Project Application 09_0165 - Redevelopment of Superyacht Marina

MP 09_0165, Redevelopment of Sydney Super Yacht Marina, Rozelle Bay

1 SOUTH ELEVATION
1 : 250

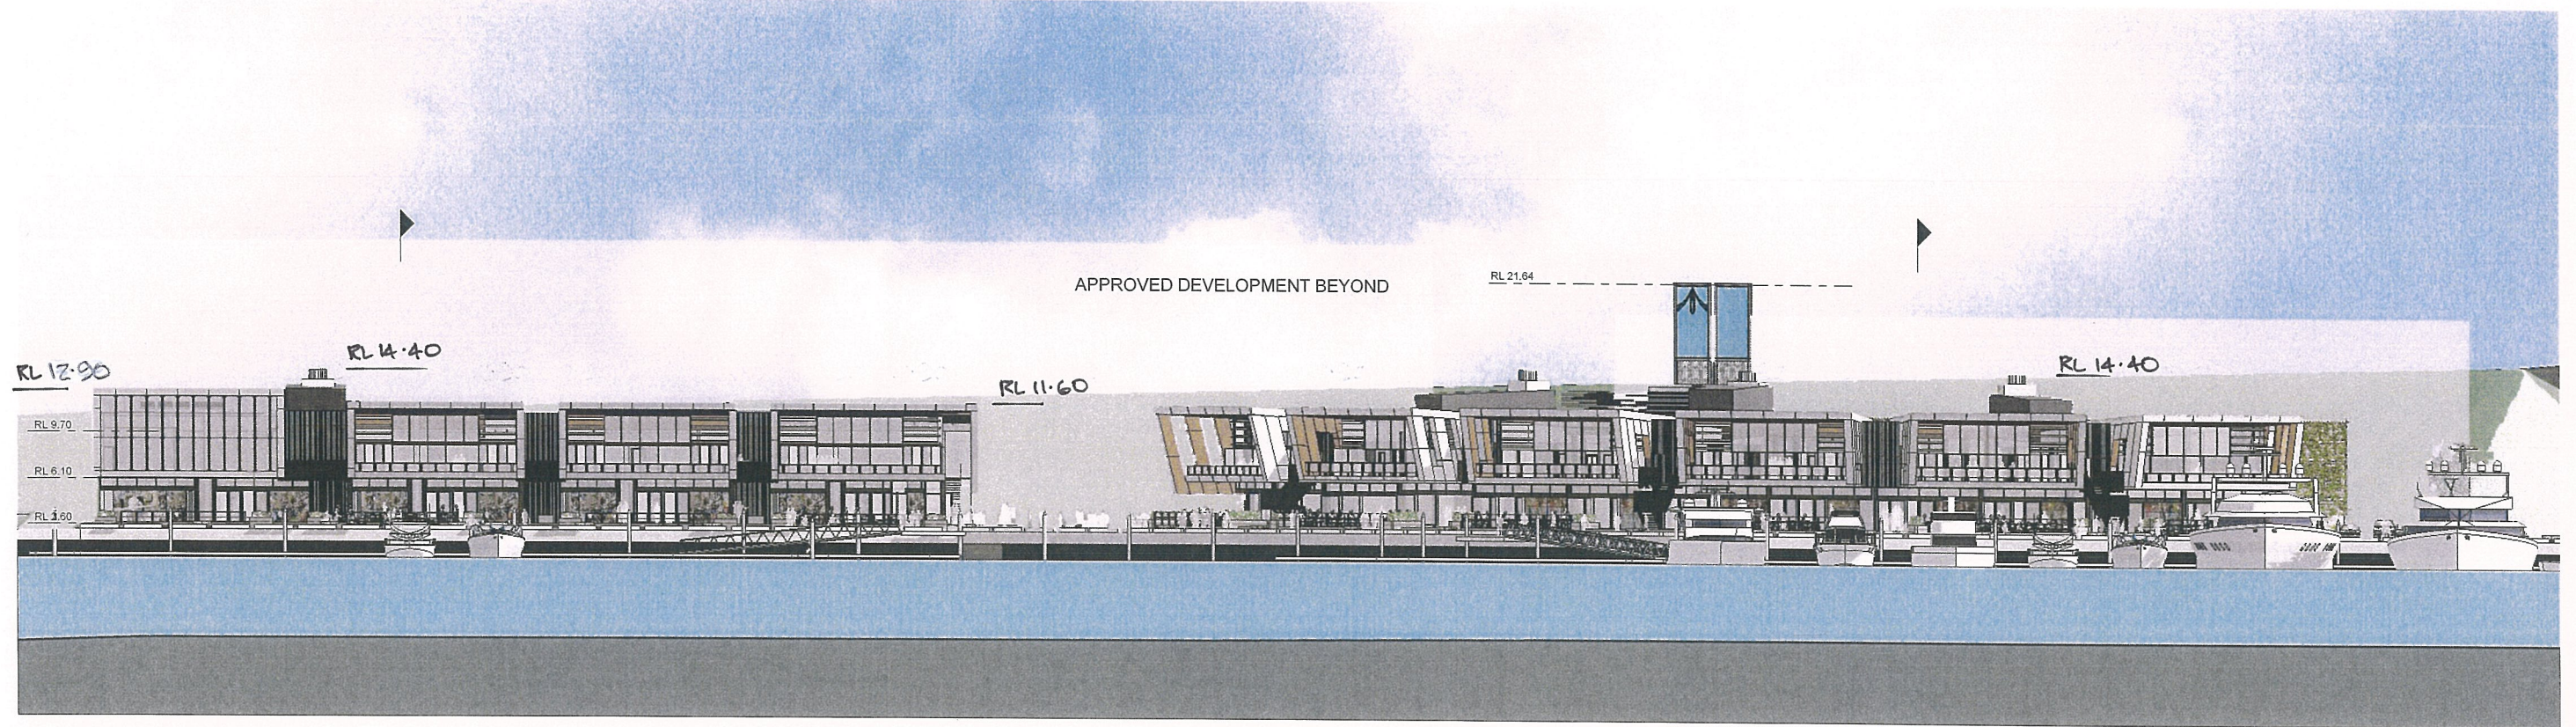
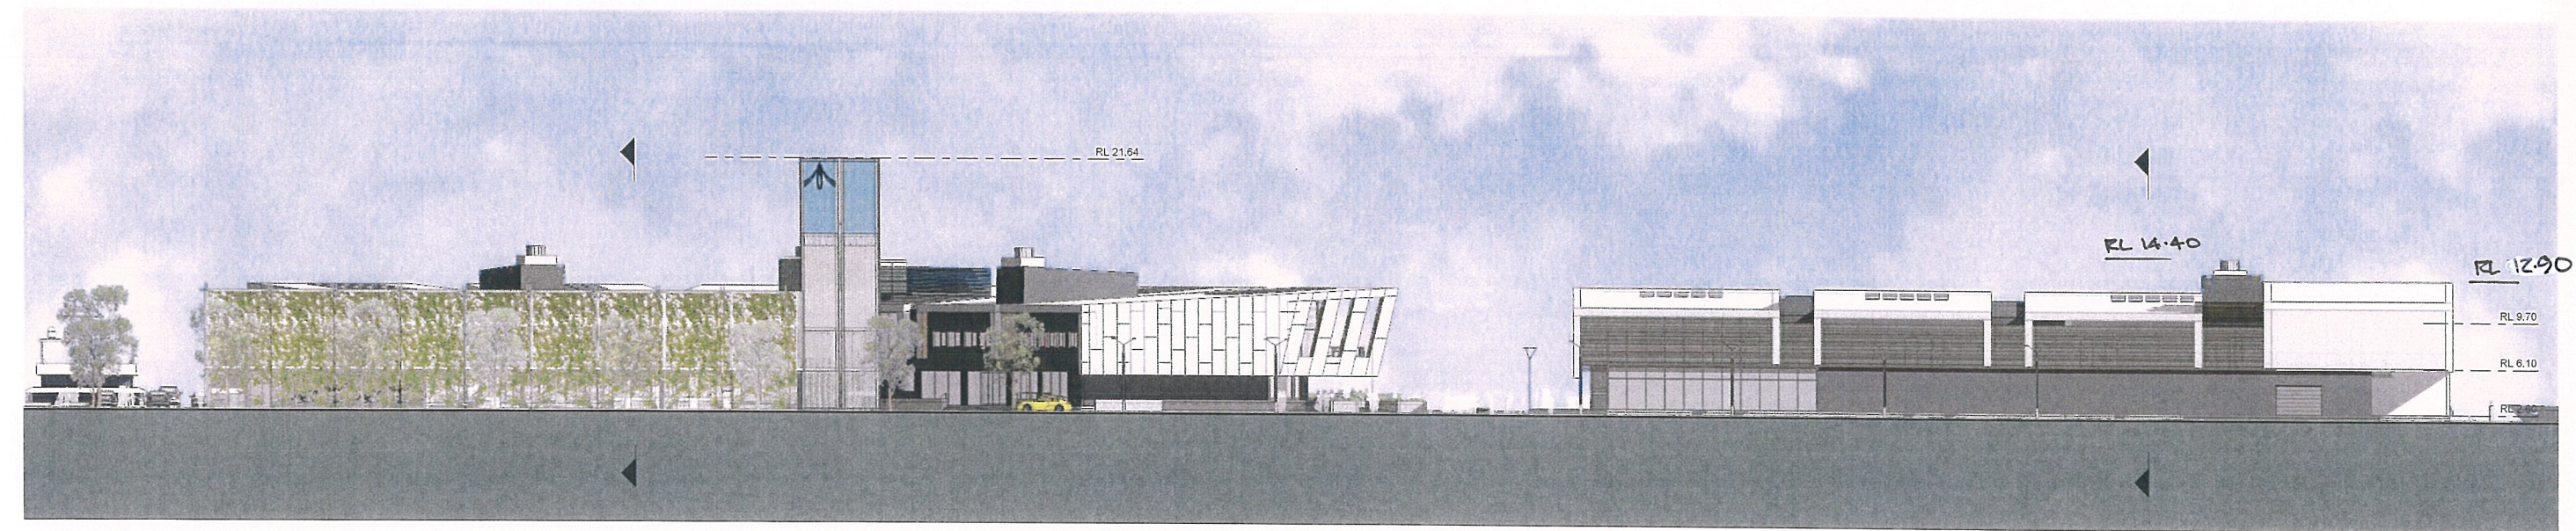
The character of the design needs to be appropriate having regard to the practicality that vessels at the marina will be viewed from the Anzac Bridge by the very large number of its users each day.

We think a simpler fenestration, suited to the large scale of the existing structures beside the approaches to the Bridge – shown in the attached sketch – would be rather more visually acceptable than the exhibited concept.

Any revision might usefully take account of the impacts of the western summer sun on the building – the exhibited concept does not appear to do so effectively.
